**Application Ref:** 3/2021/0217

**DELEGATED ITEM FILE REPORT:**

**Development Description:** Proposed double storey rear and side extension with garage conversion, new canopy to entrance door and new widened driveway to front garden.

**Site Address/Location:** 8 Whittam Road Whalley BB7 9SB

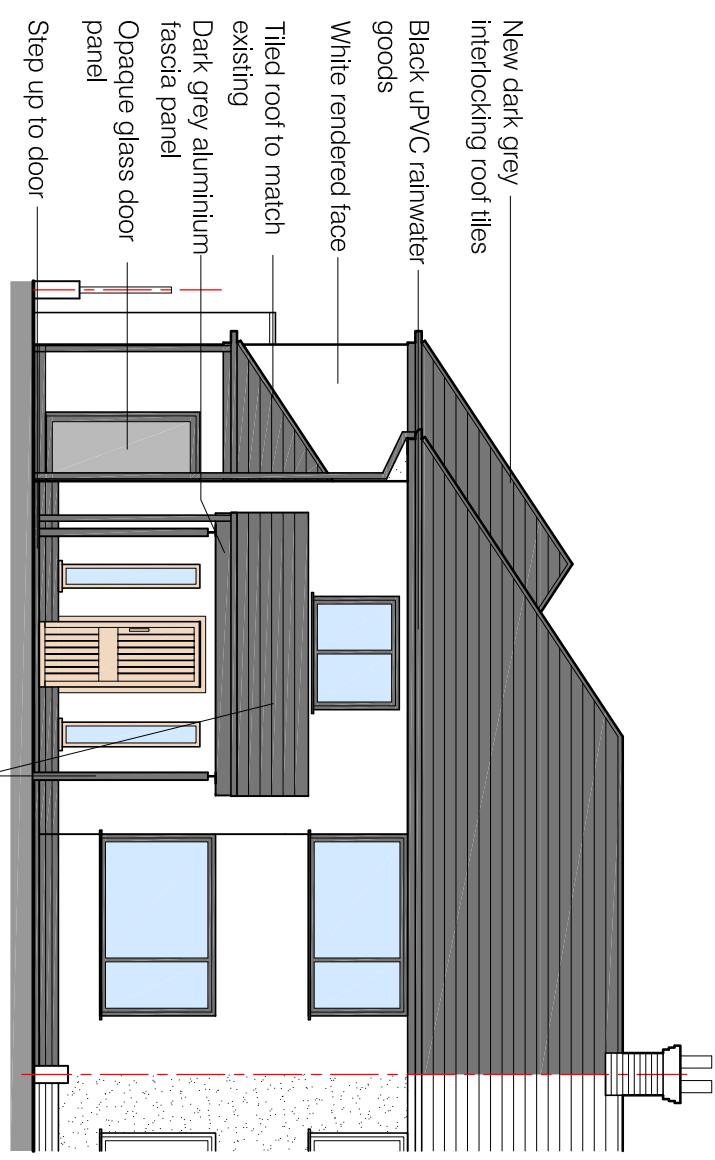
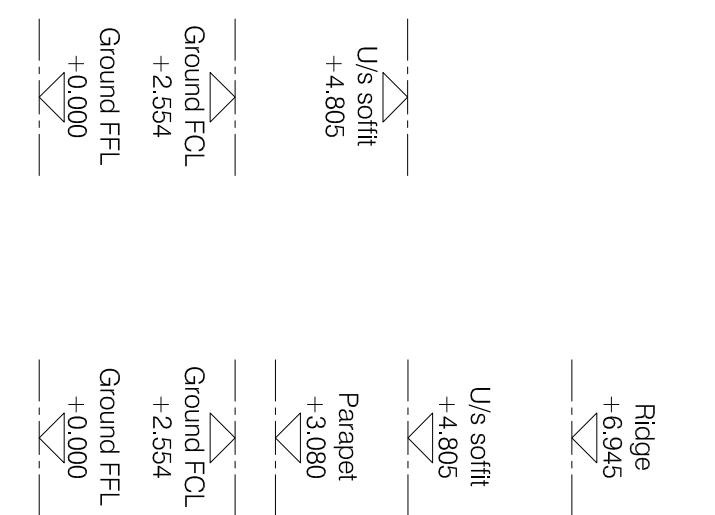
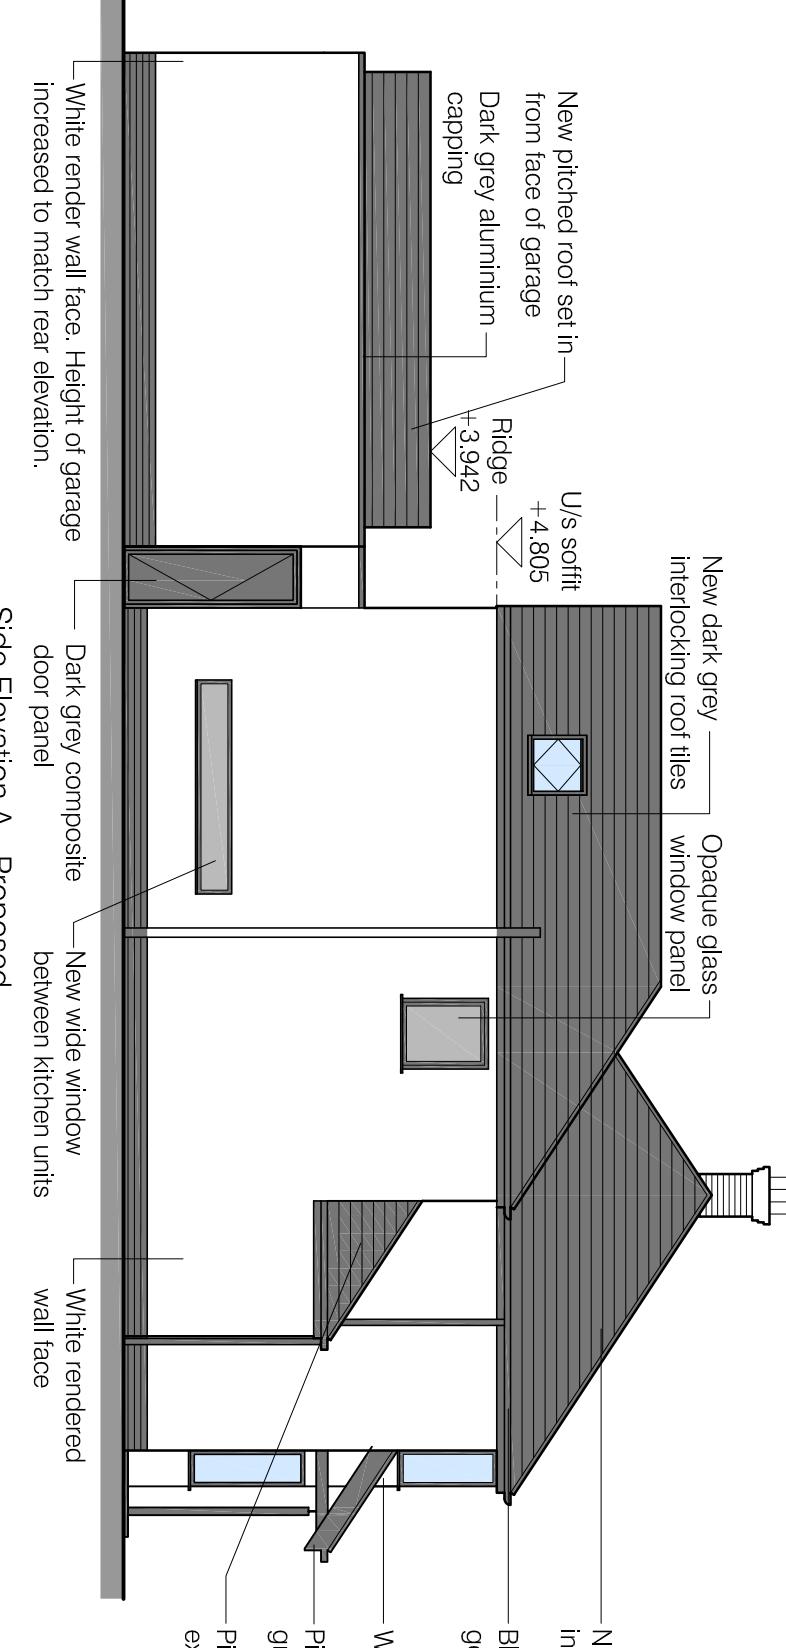
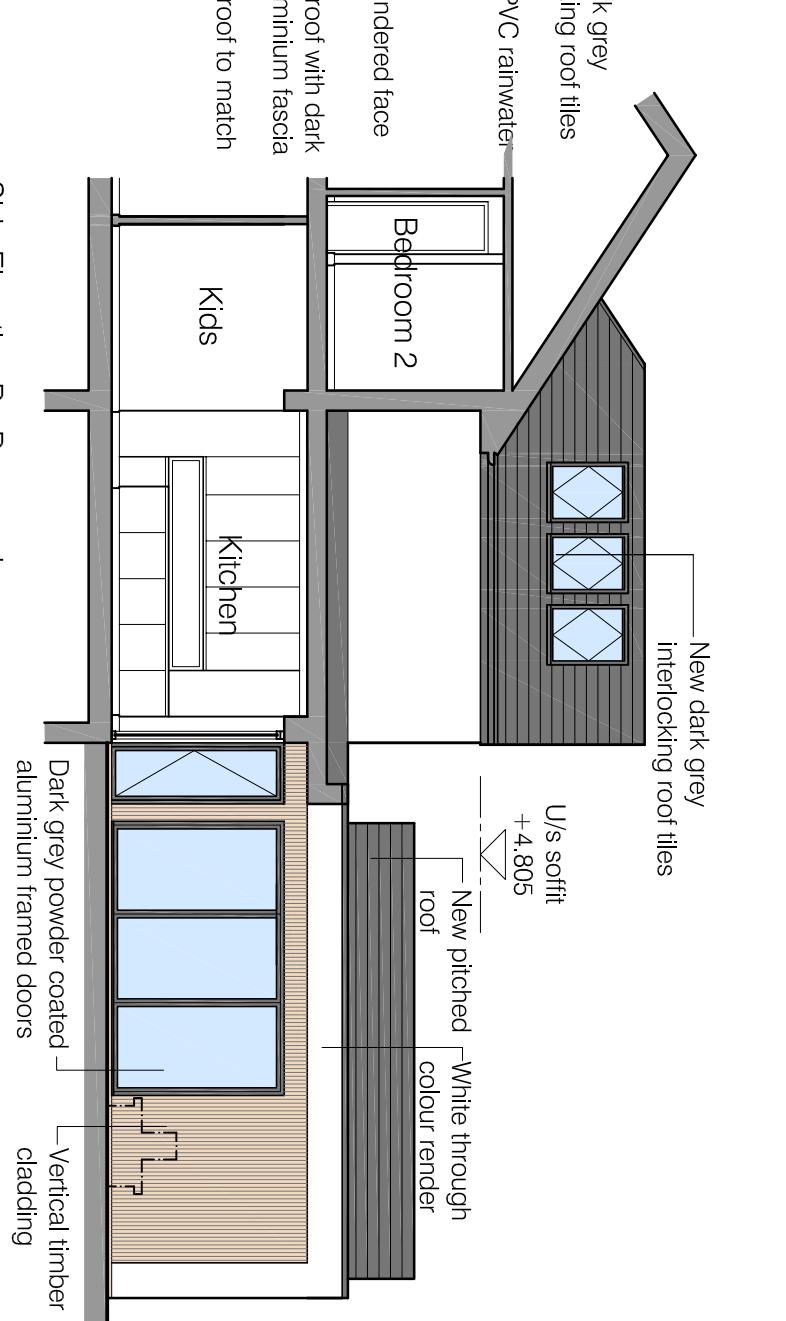
"I would confirm my concerns in respect to the incongruous and conspicuous design (form, fenestration and materials) of the first floor element of the wrap-around extension. The development has a harmful impact upon the character and appearance of the area/streetscene as viewed from The Crescent".

The revised proposals do not assuage concerns in respect to the incongruity of the first floor wrap-around extension which dominates rather than complements existing semi-detached house design (particularly conspicuous in views from the Crescent). This includes the extension gable which does not follow the hipped-roof form of the host building. This conspicuous incongruity in an estate of similarly designed dwellings is harmful to the streetscene and townscape.

In consideration to Core Strategy Policy DMH5 and DMG1, the proposed first floor wrap-around extension has a harmful impact upon the character and appearance of the area because of its undue prominence and incongruous and conspicuous form.

Revised drawings were received 7 July 2021 showing a remodelled rear elevation (timber cladding replaced with render and rectangular window now proposed to the first floor) to the two-storey wrap around extension. Some retention of front boundary wall now proposed.

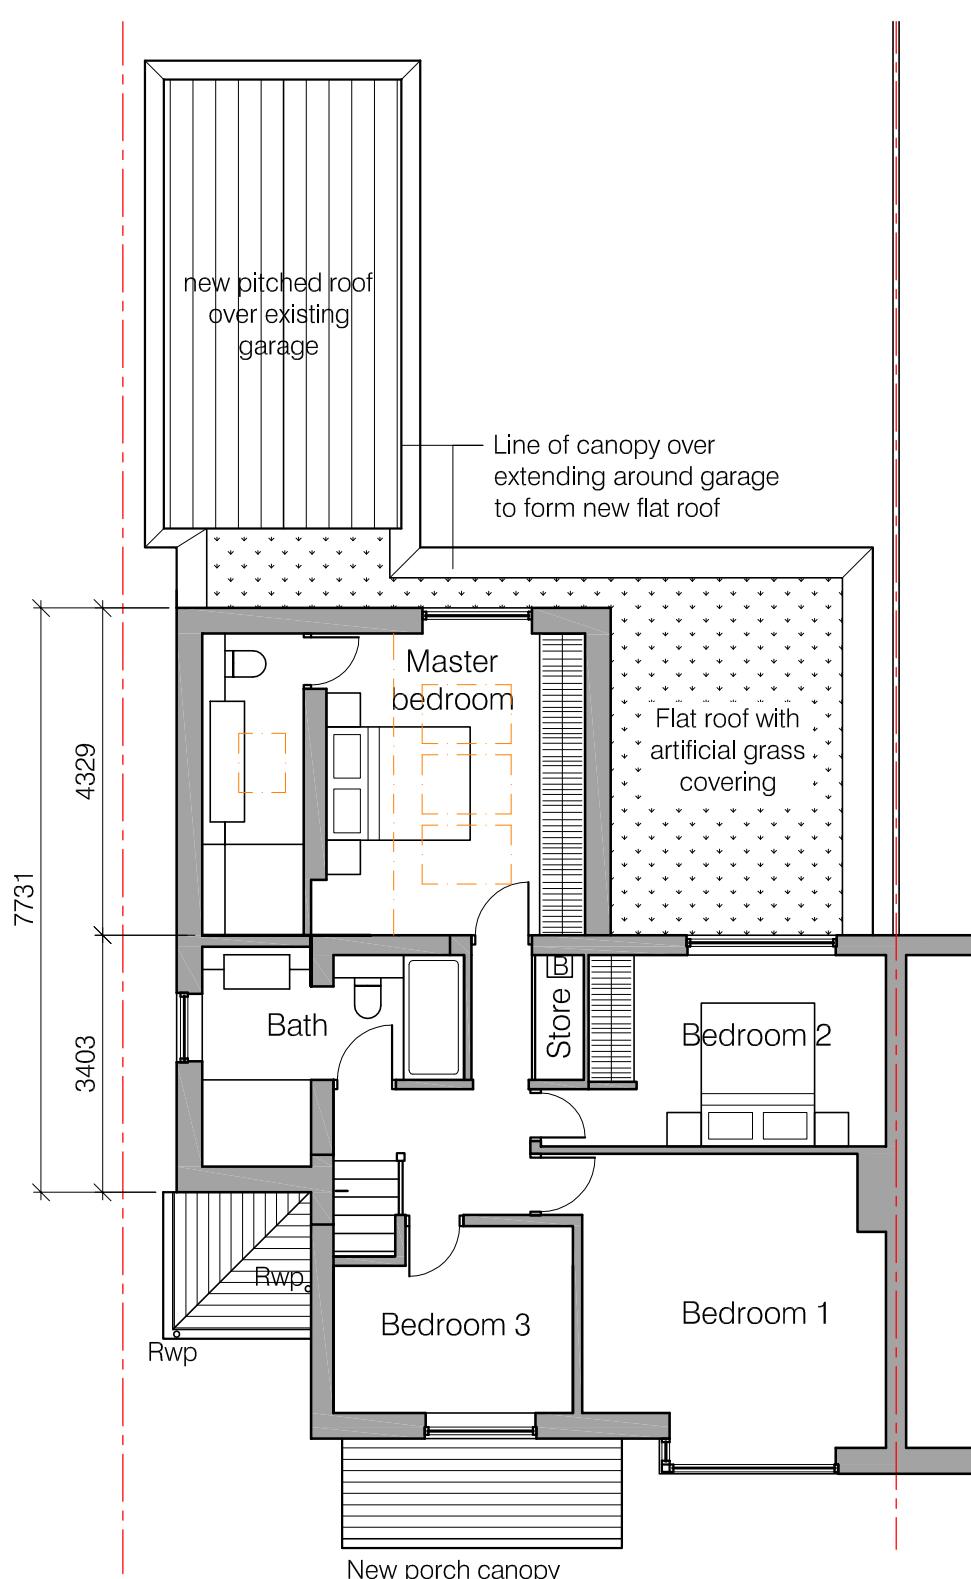
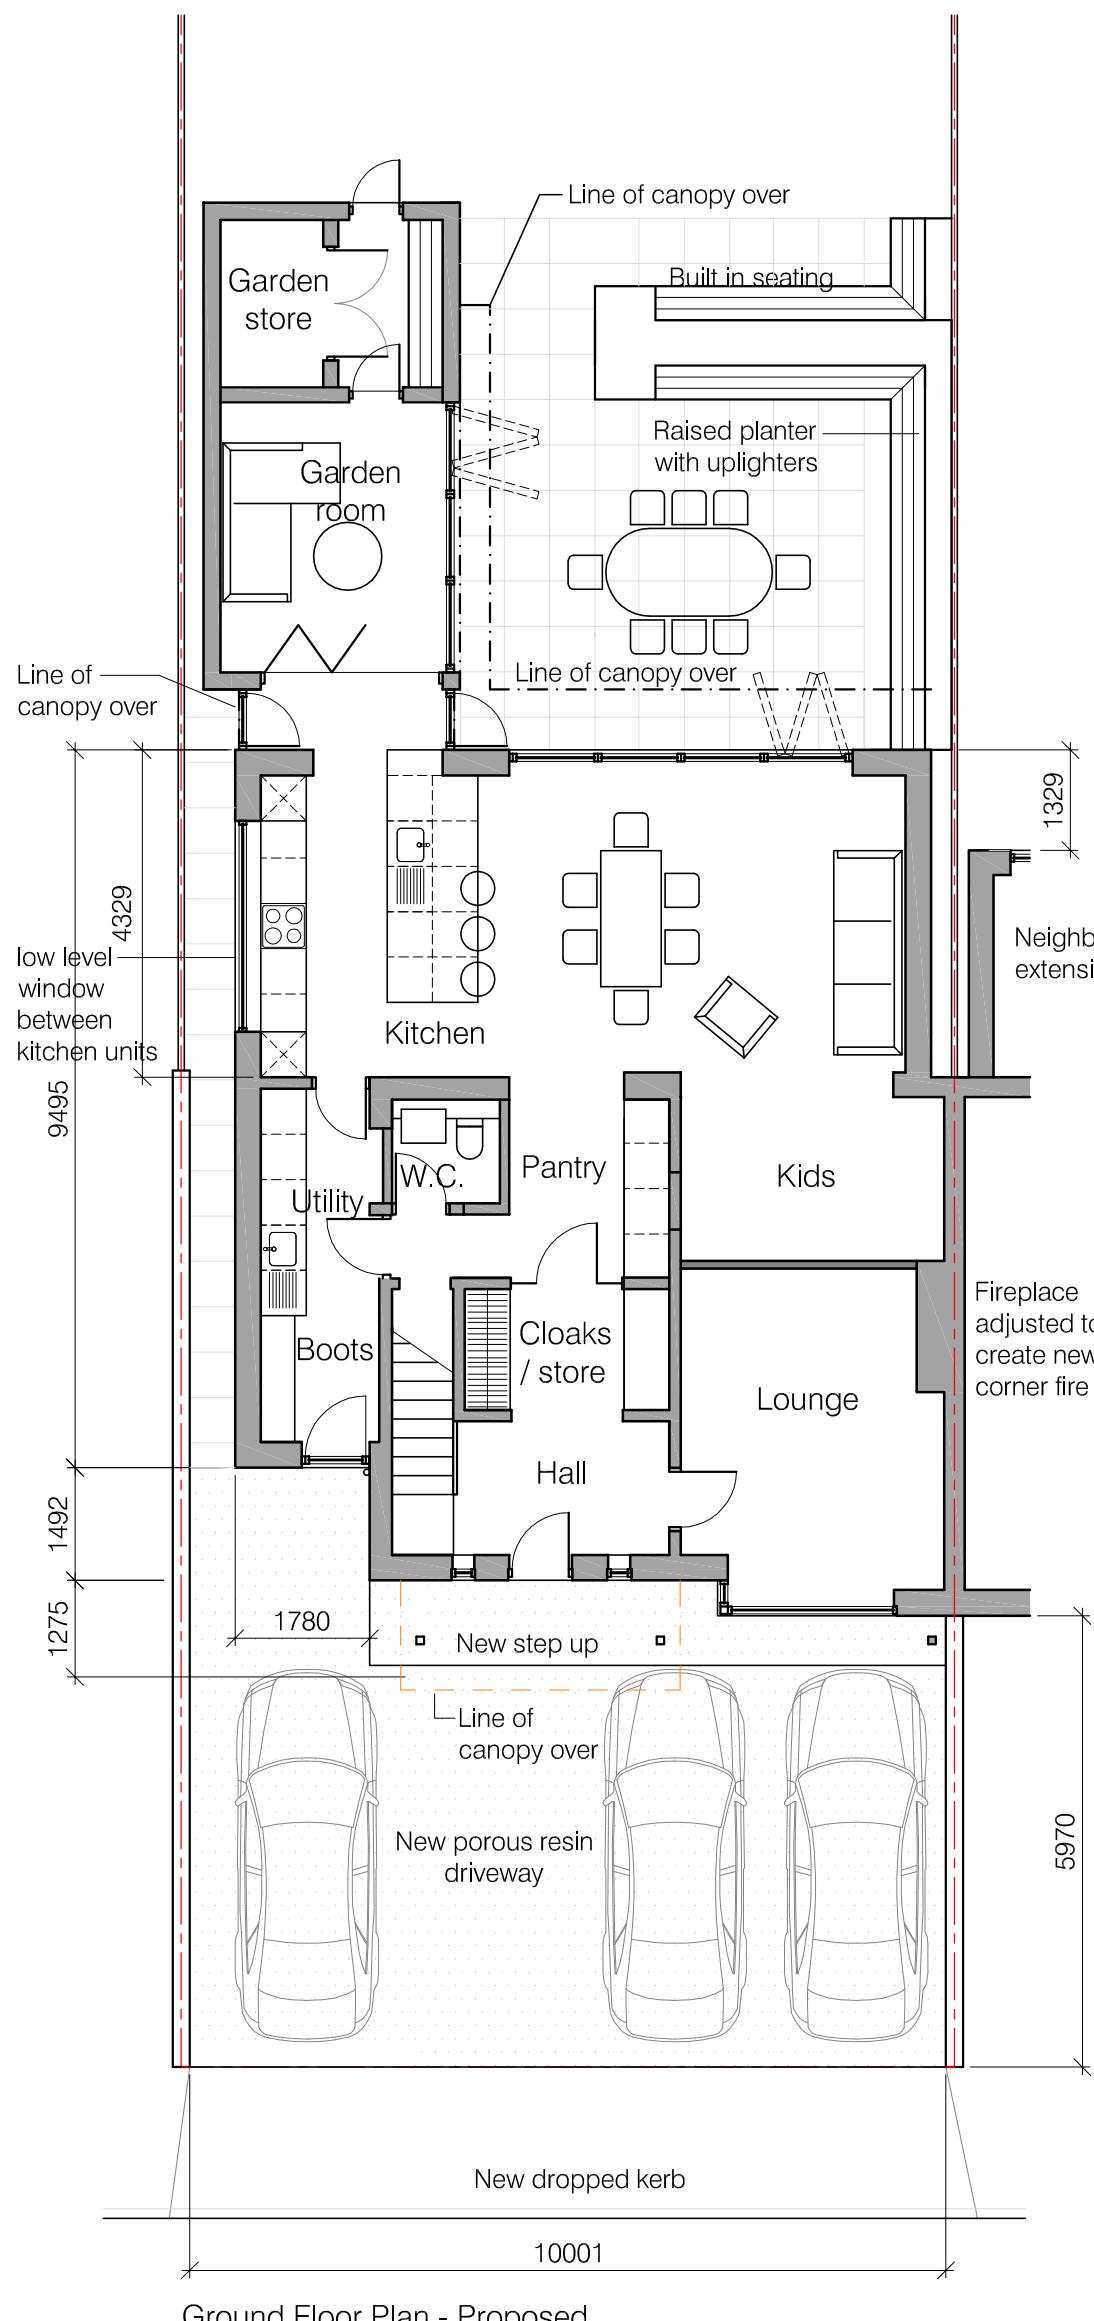
Aesthetic concerns. Flat roof with artificial grass/access to the flat roof and level of the raised planters to the rear outdoor space may impinge on the privacy of the neighbours unless at the correct height.

The proposals (rooflights facing No.6 Whittam Road could be obscure glazed; the separation distance between Garden Room glazing and the boundary with No 6 is considerable and fencing height could be increased) have an acceptable impact upon the residential amenity of neighbours (including overlooking, overshadowing, overbearing impacts).

The aesthetic concerns of the Parish Council have been considered. The flat-roof on the single-storey extension is acceptable because it defers to and does not dominate the host building.
